Outline Application for the erection of 18 No. dwellings
Pound Place Roundstone Lane Angmering

Thank you for your internet representation made on 13th November 2014 which has been recorded as '**an objection**' with the comments as follows:

SITE PLAN

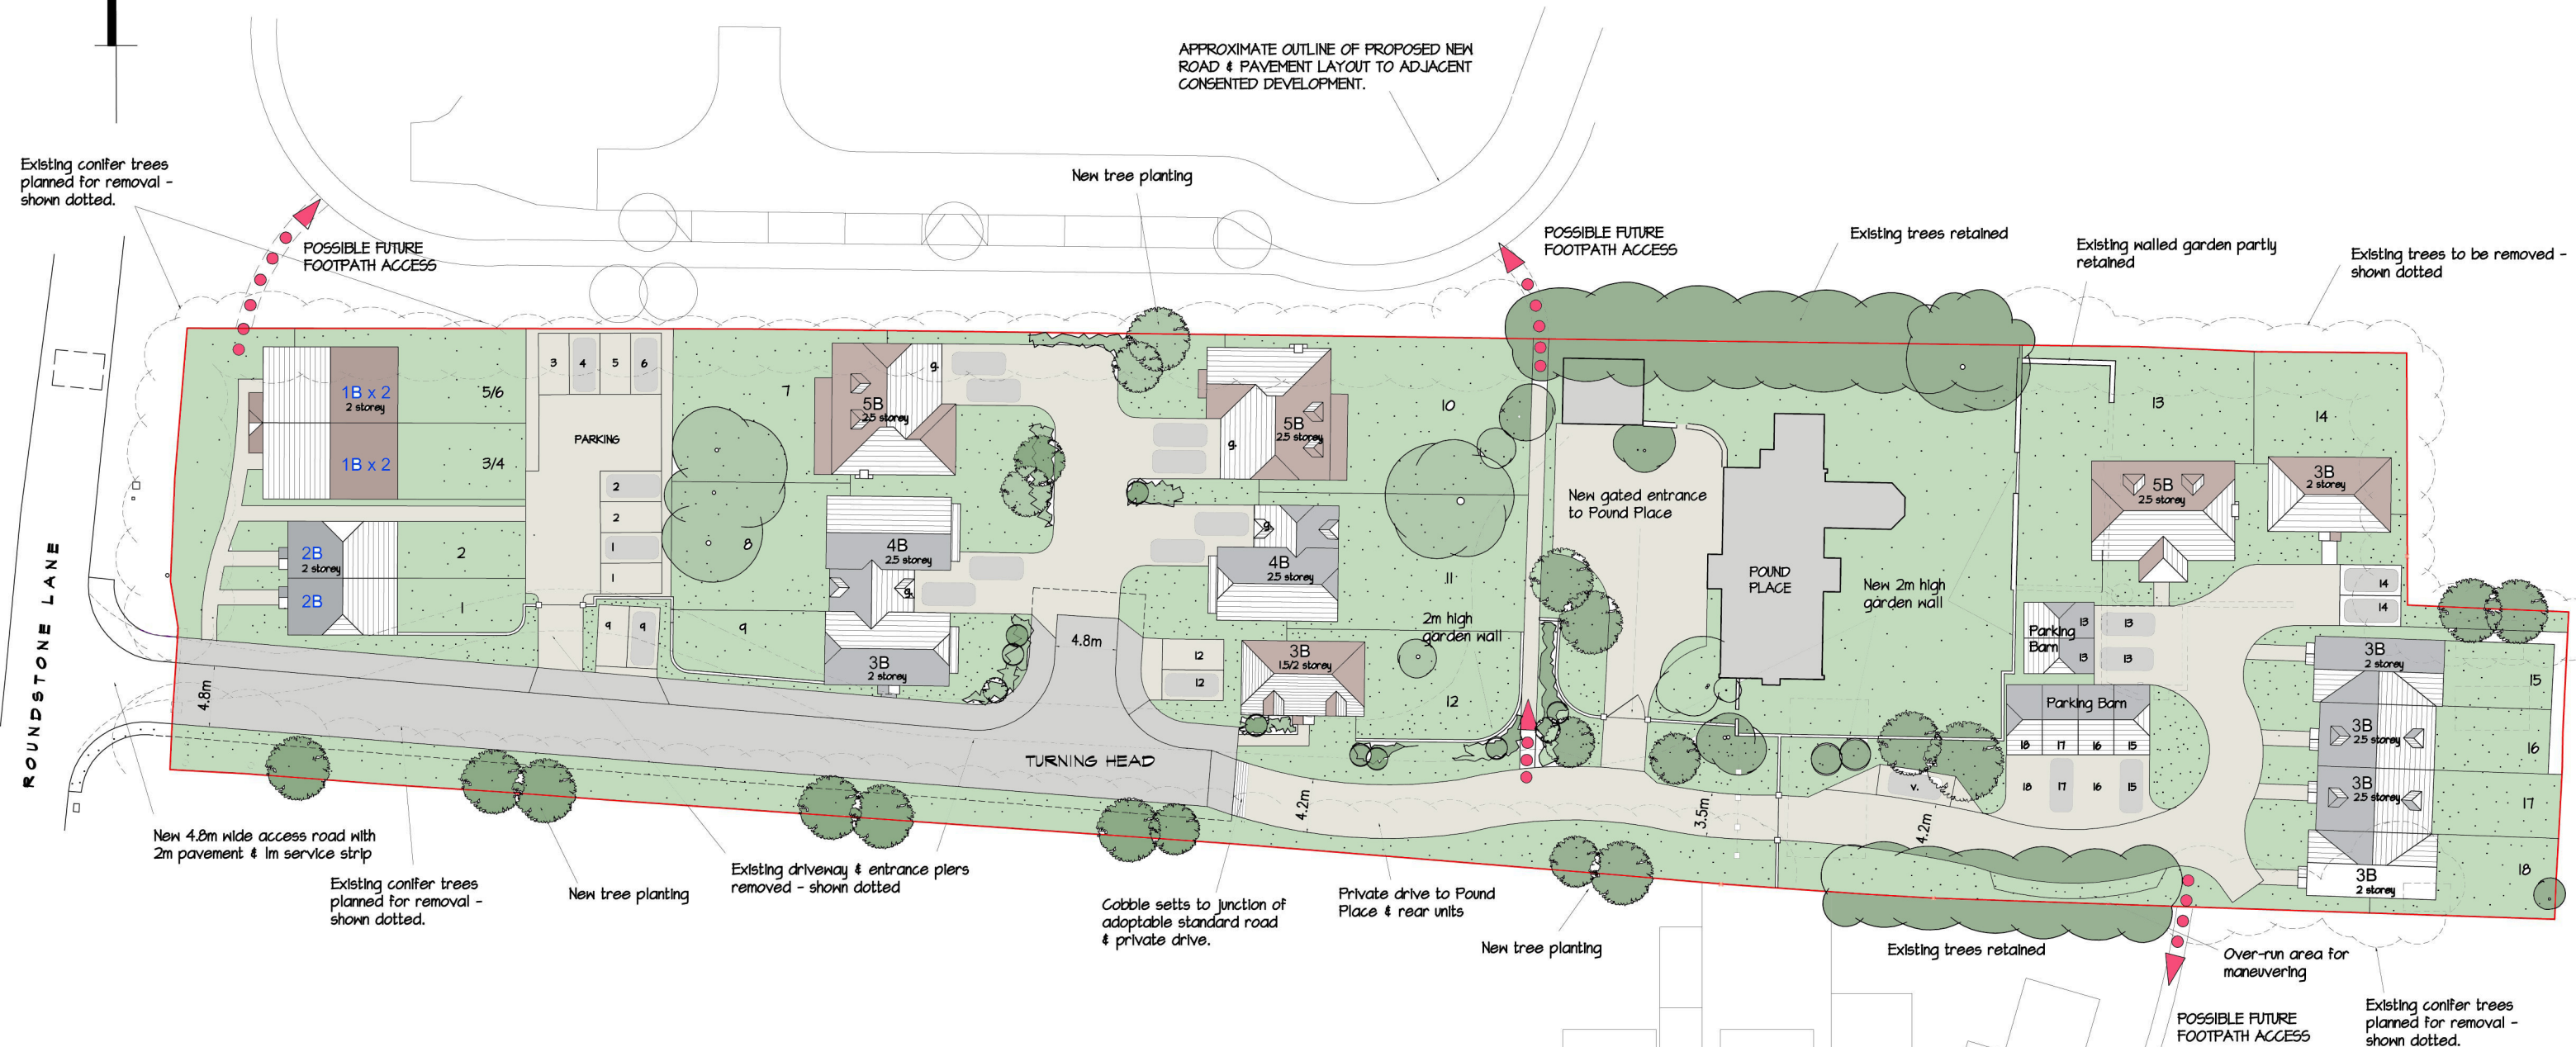
Not enough parking especially for the affordable housing. Most families have 2 vehicles and possibly a work vehicle as well. That is not counting visitors and delivery vehicles. They will park along the narrow access road causing congestion and obstruction for emergency and service vehicles. Garages are too small to be used as a parking space and are rarely used as such by owners.

The entrance has pavements going nowhere as Roundstone Lane has none in this area. Unsafe for pedestrians as crossing will be hazardous. Space within parking areas looks cramped and manouvreing in them will be difficult. Refuse and emergency vehicles will have turning problems. No amenity areas for small children. No cycle routes. This development is not needed in light of all the other housing allotted to the adjacent sites. Just shoe horning in as much as possible to make money with no real thought to the problems it will cause to residents.
